28 March 2024

**ALDINGBOURNE PARISH COUNCIL SUBMISSION TO ARUN DISTRICT COUNCIL ON AL/11/24/OUT,
'LAND EAST OF WESTERGATE'**

Application Details: Hybrid application consisting of 1) Outline permission for all matters reserved (except access) for up to 400 No dwellings and associated works and 2) Full planning permission for alterations to site access off Westergate Street and through Pine Close and east-west link road including a bridge over the Lidsey Rife. This application also lies within the parish of Barnham, falls within Strategic Site SD5, CIL Zone 1 (Zero Rated), affects the setting of listed buildings, affects the character and appearance of the Eastergate Church Lane Conservation Area, affects public rights of way. This application is the subject of an Environmental Statement.

Figure 4-1 - A29 Level Crossing AM Peak Queue Lengths

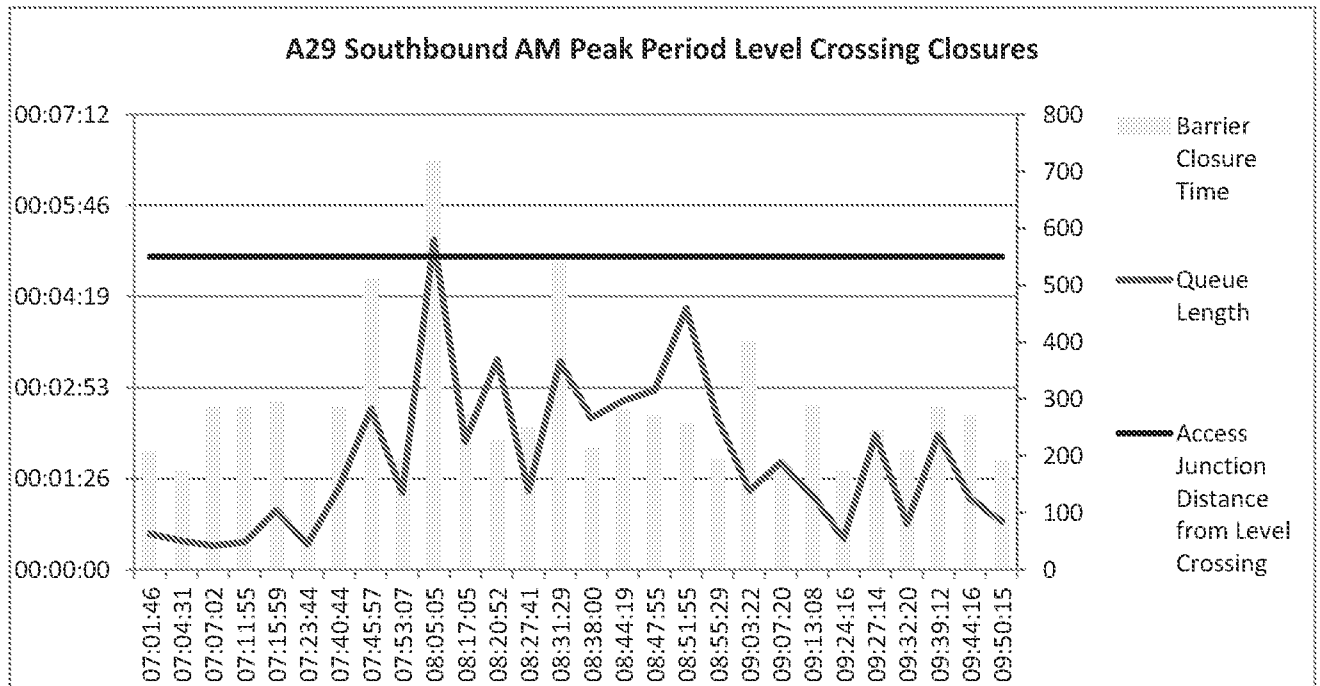
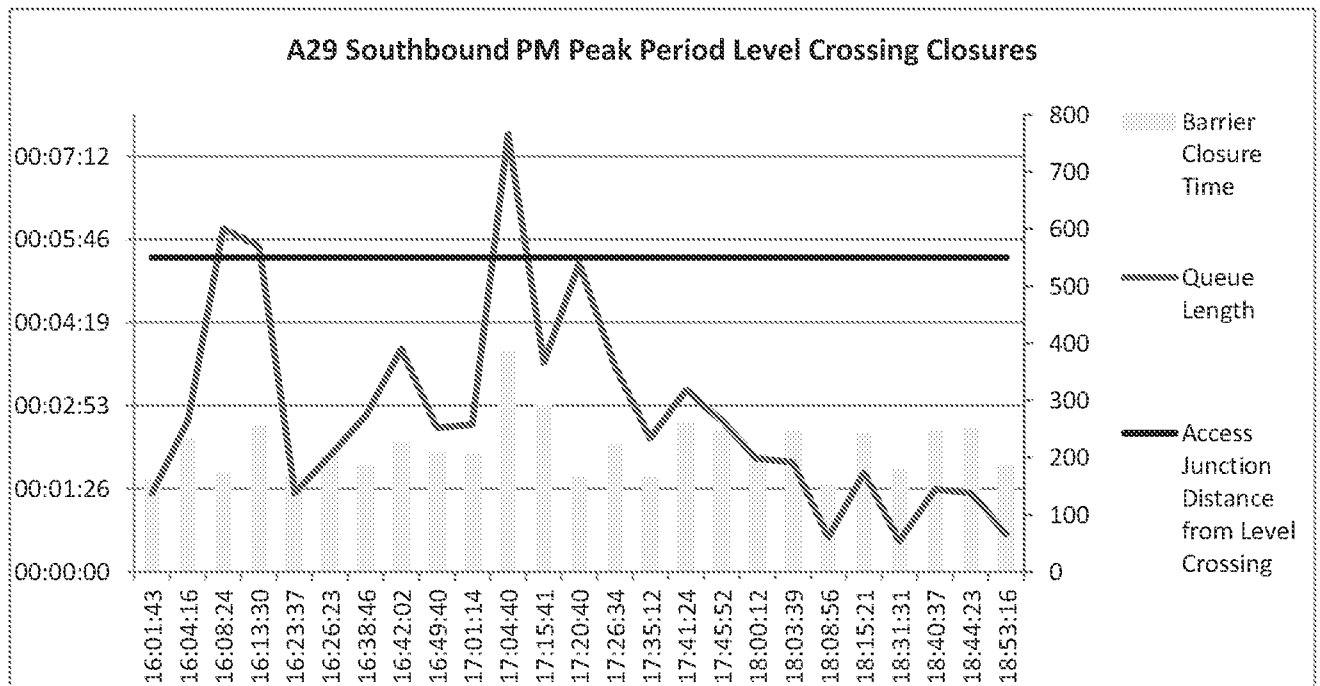
- 1.2.2 The Woodgate level crossing is currently estimated to be closed for around 92 regular 'timetabled' movements each way per day, Monday to Saturday, along with additional closures for freight trains, relocating trains and touristic services. The actual closure duration each hour of the day will need to be provided by Network Rail, but we calculate that from June onwards when a new timetable takes effect, the crossing will be closed for at least 30 – 35 minutes in every hour the service operates. Traffic queues will therefore increase even further and block entry from and to Pine Close even more frequently.
